## Union Park, Bulls Bridge Industrial Estate

### – GLA feedback

**A90 - EXTERNAL WORKS
B4 Enlarged Site Plan**

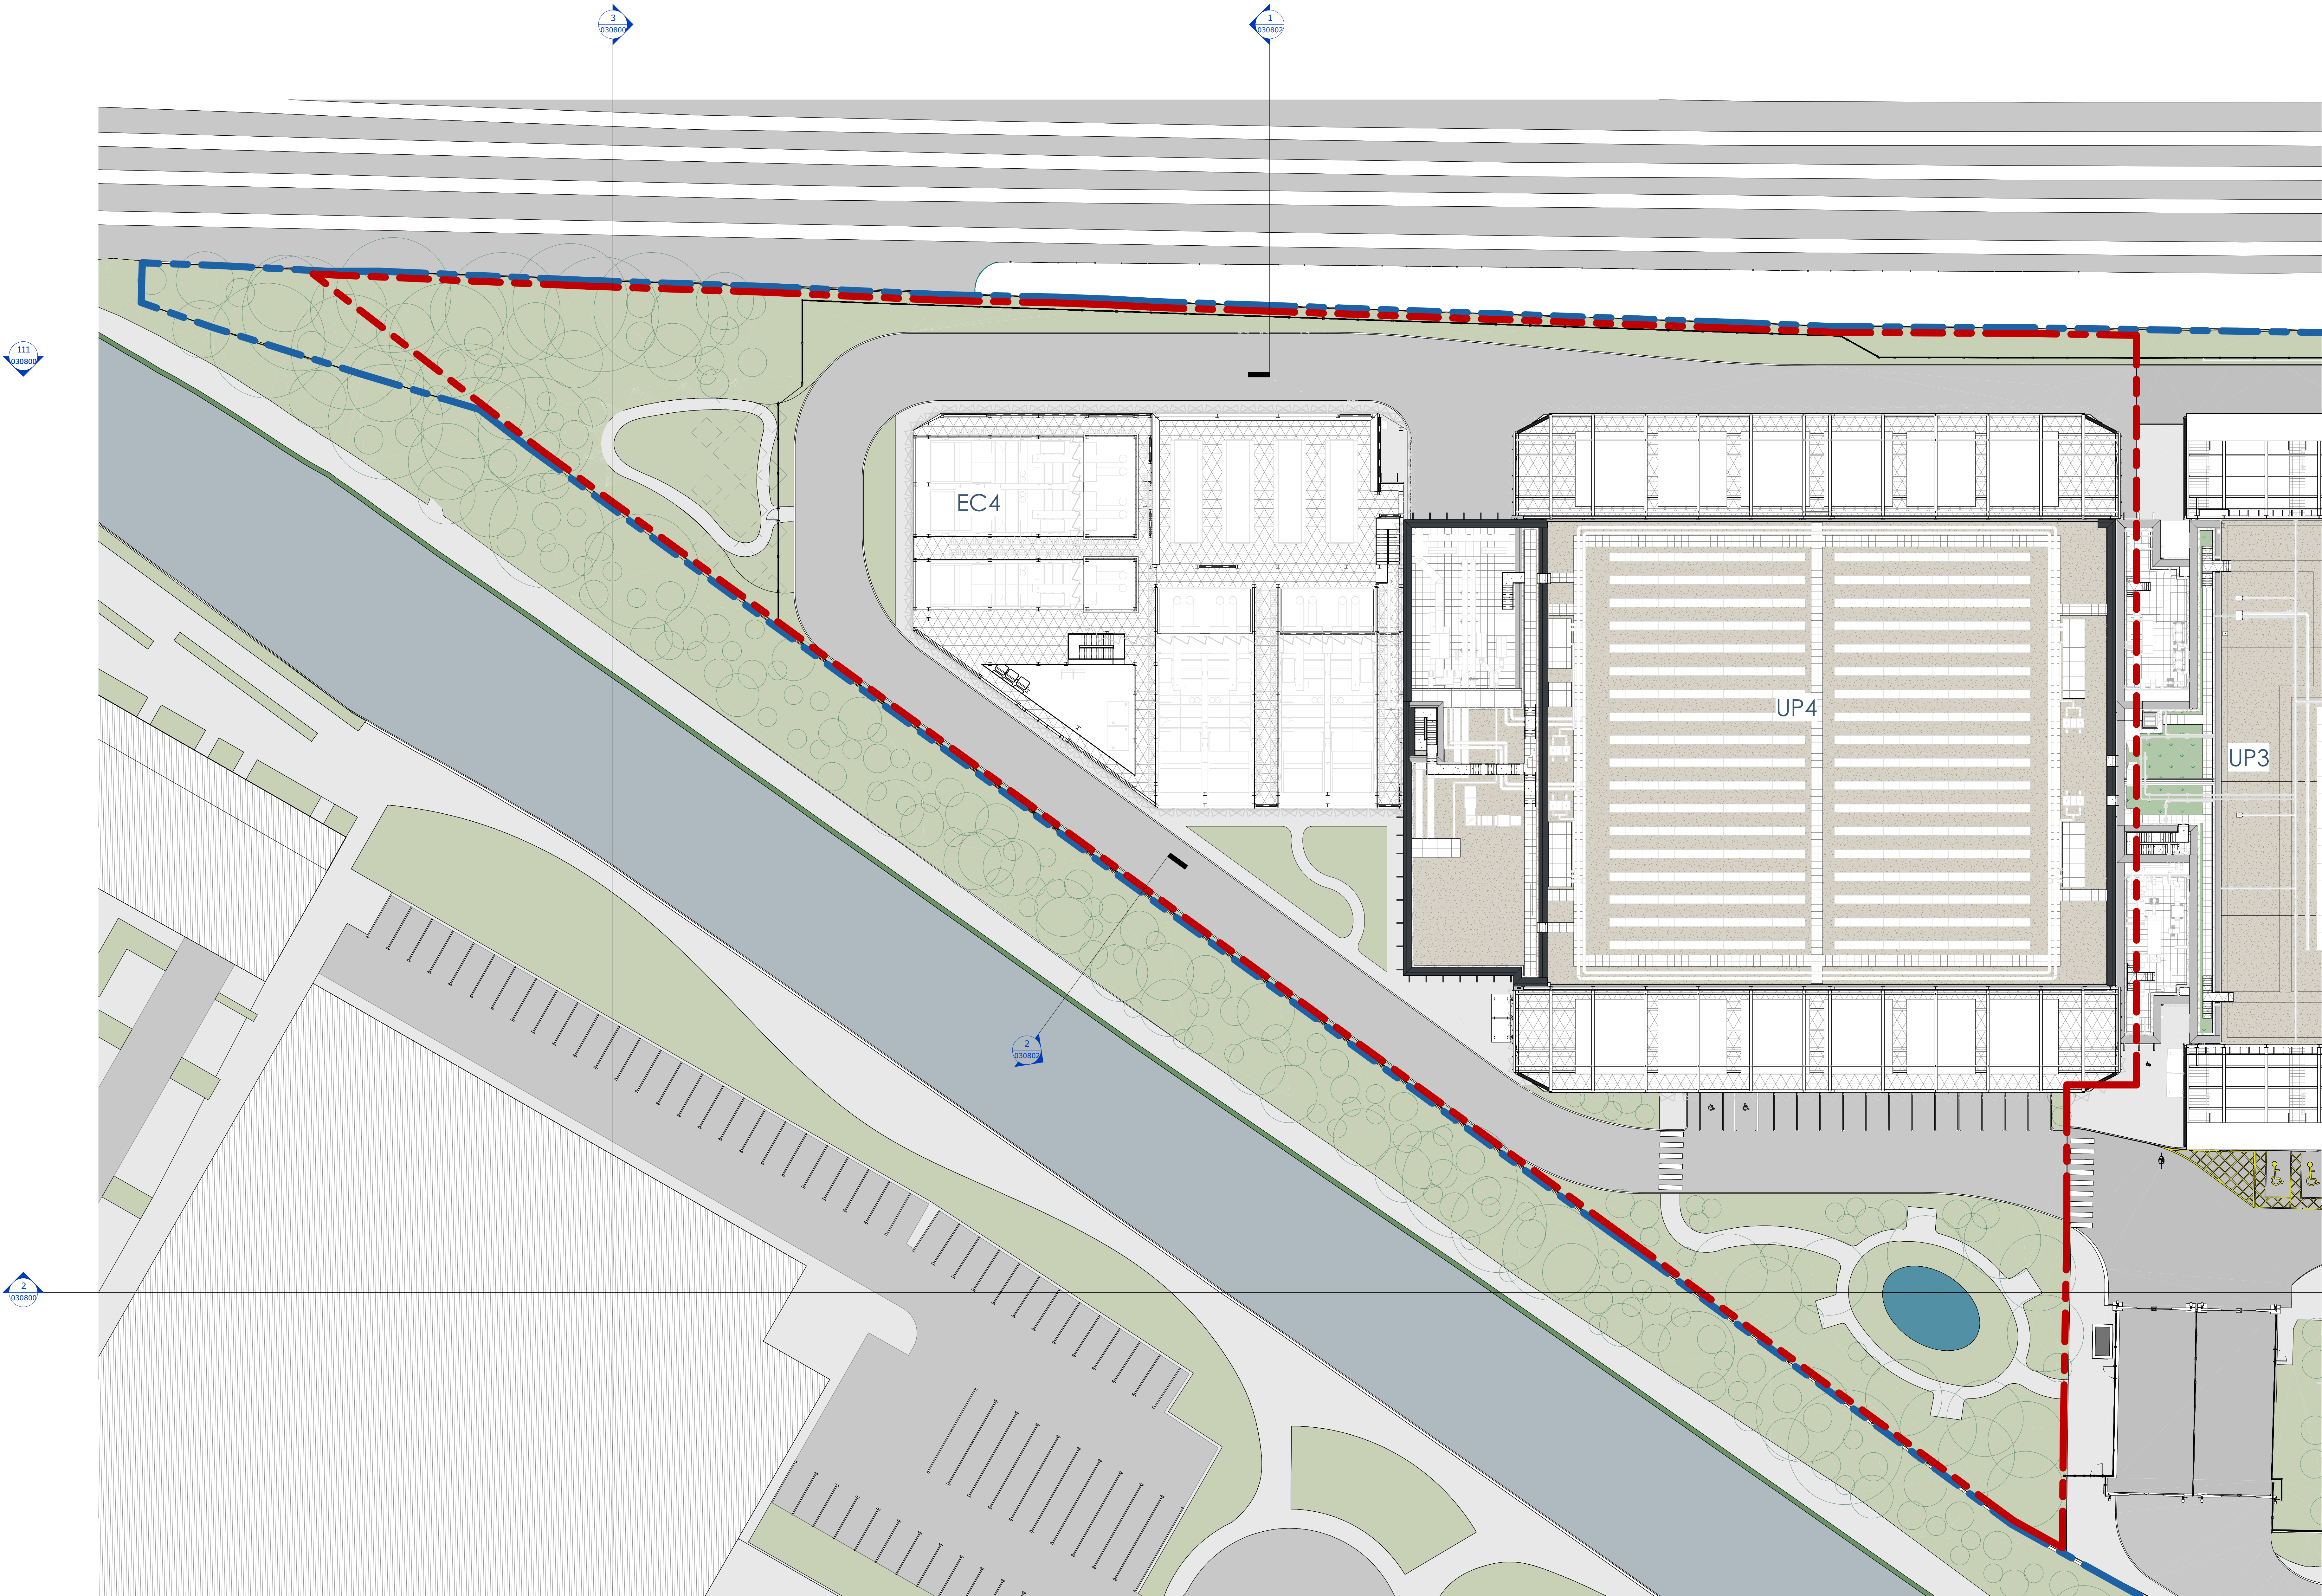
21. The requirement for a continuous internal road loop appears to create layout inefficiencies and additional hardstanding. A reduction in the dominance of vehicle routes would be welcome, along with provision of safe and inclusive pedestrian and cycle paths. The extensive use of security fences should be reconsidered and minimised, with alternatives such as landscape features and built form being appropriate solutions that could contribute positively to the surroundings.

The loop road provides a continuous vehicle route allowing access to entrances and delivery bays around the campus; this minimises the requirement for vehicles to reverse, particularly large cranes / lorries needed for infrequent plant replacement. Minimising vehicle reversing is a key safety principle.

Pedestrian entrances and routes are located to the south of the building adjacent to the site entrance, with an option to walk through the Wellbeing Garden. This makes the access sequence intuitive and minimises the extent that pedestrians need to walk adjacent to vehicle routes. Similarly, the cycle parking provision is to the south of the building adjacent to the pedestrian entrance, removing the need for cycling around the west and north of the building, this removes the need to cycle towards the service areas to the north of the building, where the risk to cyclists would be greater.

The extent and design of the security fencing has been reviewed extensively with the Local Planning Authority and the Design Review Panel, including a site visit. The design is considered necessary to address the concerns of the Metropolitan Police Service Counter Terrorism Advisor, raised following the designation of data centres as Critical National Infrastructure. The fencing with razor wire topping has been limited to the north site boundary only, adjacent the Network Rail line.
